Christ Church  
Project Name/Description

RE: Building Addition  
Job ID #2001-0134, CBL #212-A-025

Subject: Building Addition  
(CBL# 212A025 ID #2001-0134)

SUBJECT: Christ Church, 1900 Congress Street

AA. 5

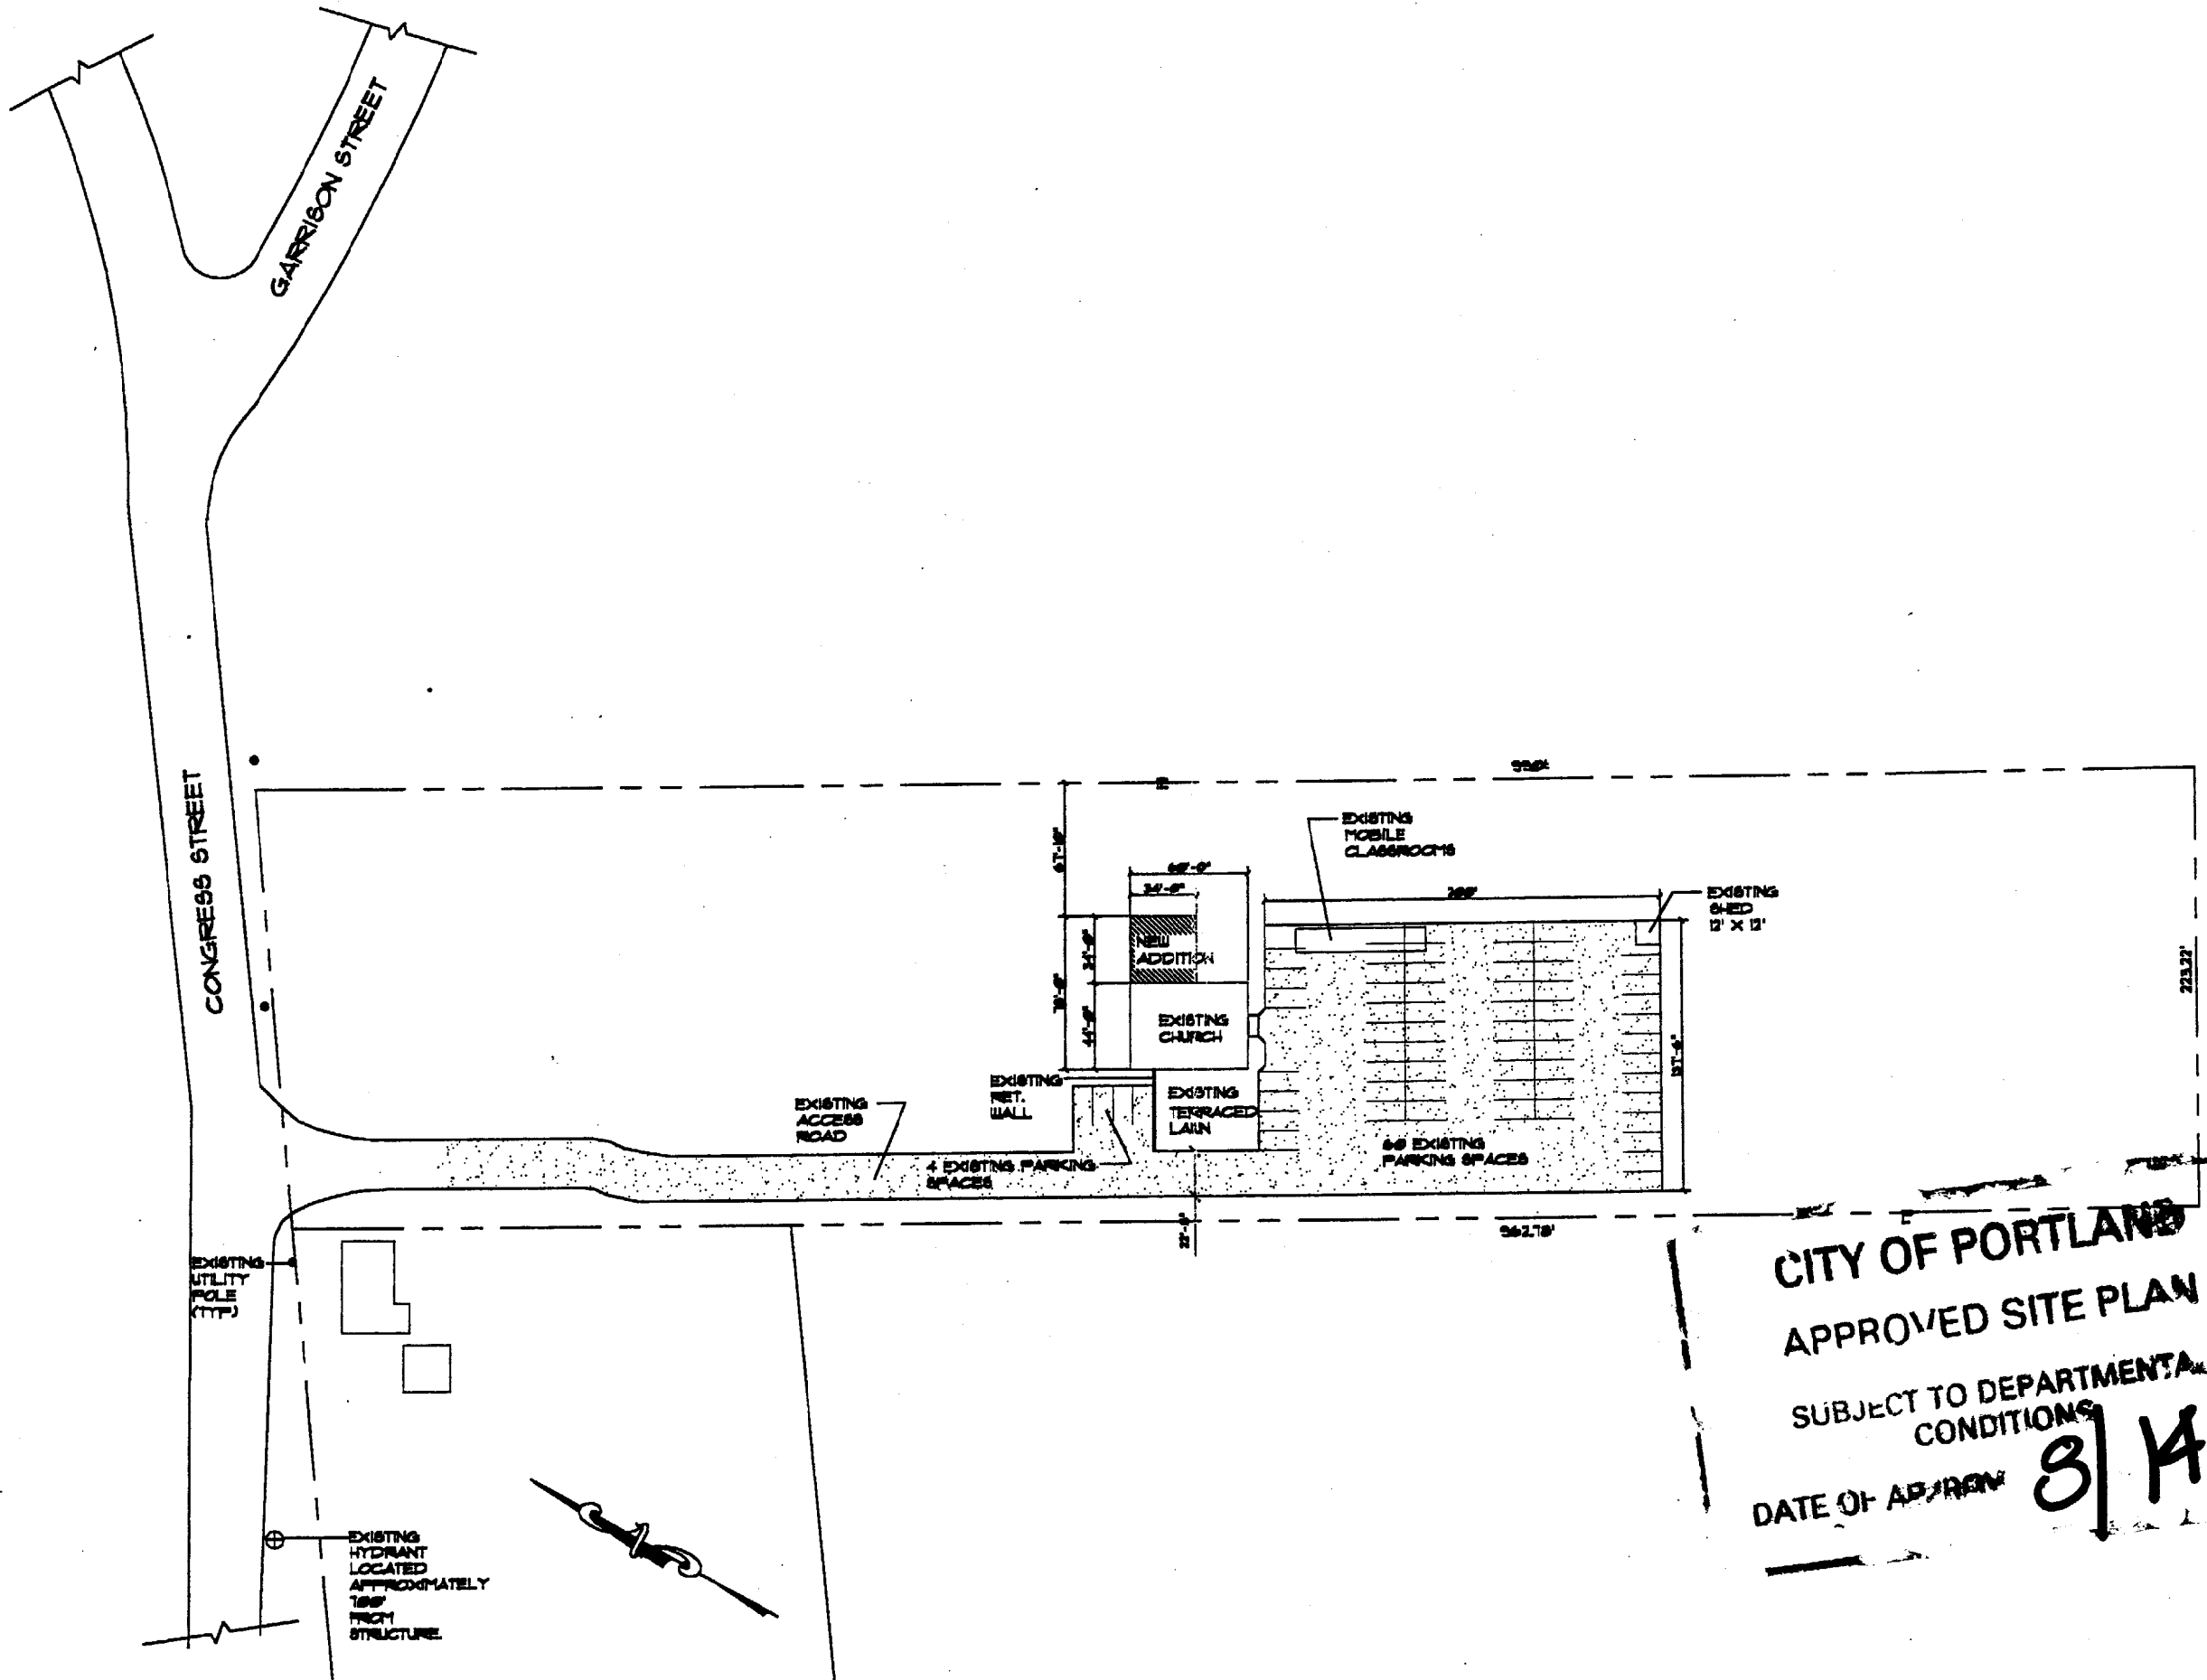
On September 16, 2002, the City of Portland sent you a letter asking that you submit to the City an amendment to the approved site plan for Christ Church of Portland because a pipe was found on your site, which discharges onto a neighboring property. This pipe was not indicated on the approved site plan.

1. Drain Installation: A 4" diameter polyethylene pipe was found on your site which discharges onto a neighboring property. It appears to be either a roof drain or foundation drain discharge. This was not indicated on the site plan, but more importantly, it is directed onto another property.

This condition will need to be corrected by redirecting the pipe to an acceptable discharge location within your property. There is an undisturbed wetland-type area on your property that appears to be a suitable discharge location for this pipe. It also appears that the grades and elevations would allow for this to occur.

Please submit to the City an amendment to your site plan. This should reflect the changes needed to accomplish the pipe redirection.

Currently stormwater runoff flows down the hill towards a drainage ditch running adjacent and parallel to Congress Street. The applicant has stated that standard erosion control measures will be used during construction. The applicant should revise the plan to show location of erosion control measures, such as silt fence, etc.

A4. 7

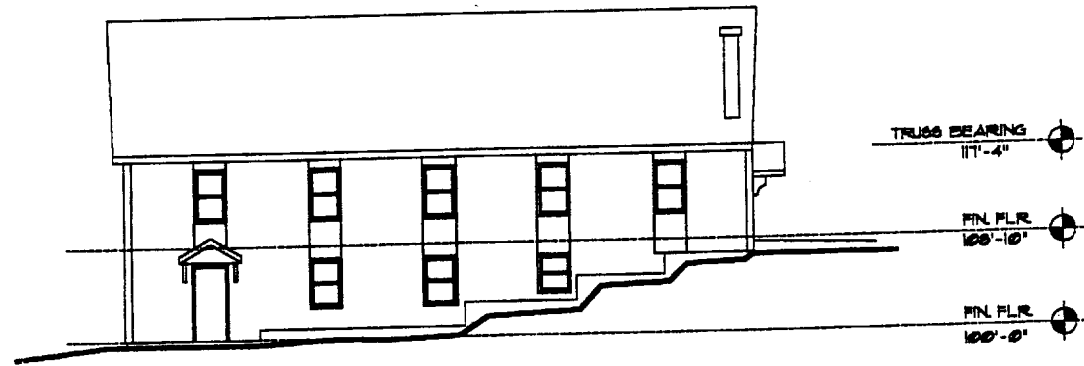
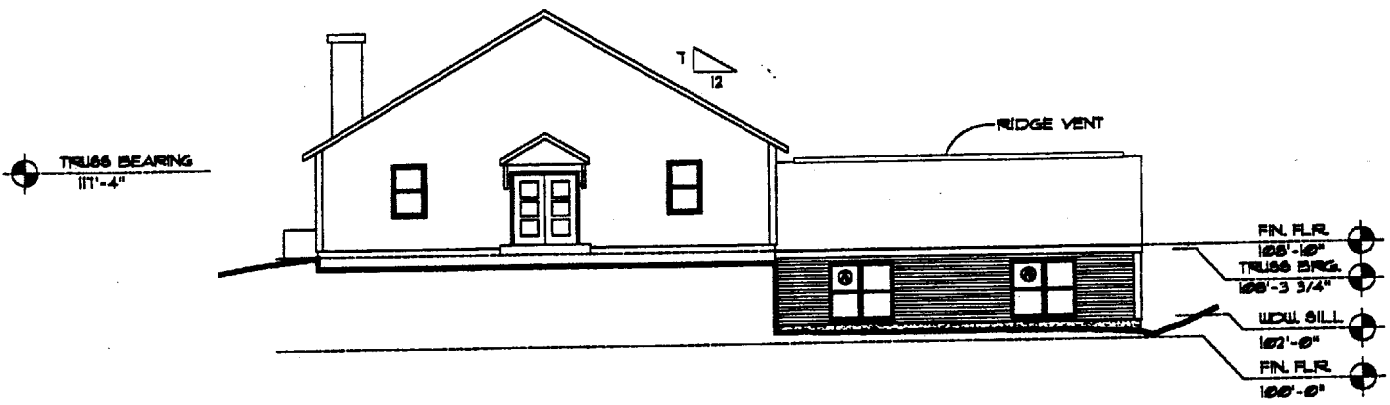
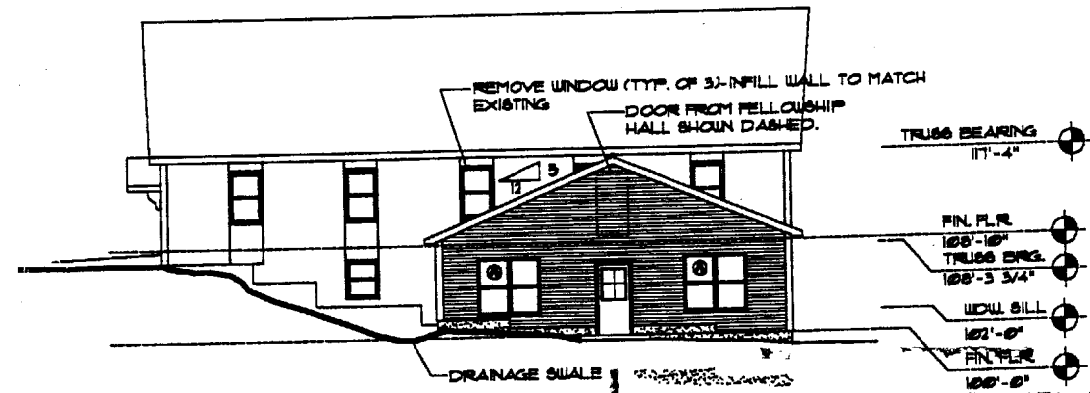
The applicant is proposing to construct a 1,156 sq. ft. addition to the existing building. It appears that the facade will consist of either clapboard or vinyl siding. The applicant will need to submit further information regarding the material of the façade. Elevations drawings are included as Attachment 7.

The applicant is proposing to construct a 1,156 sq. ft. addition to the existing building. The façade will consist of painted cement clapboard with 4" exposure. The applicant will be providing a sample of the cement clapboard at the public hearing.
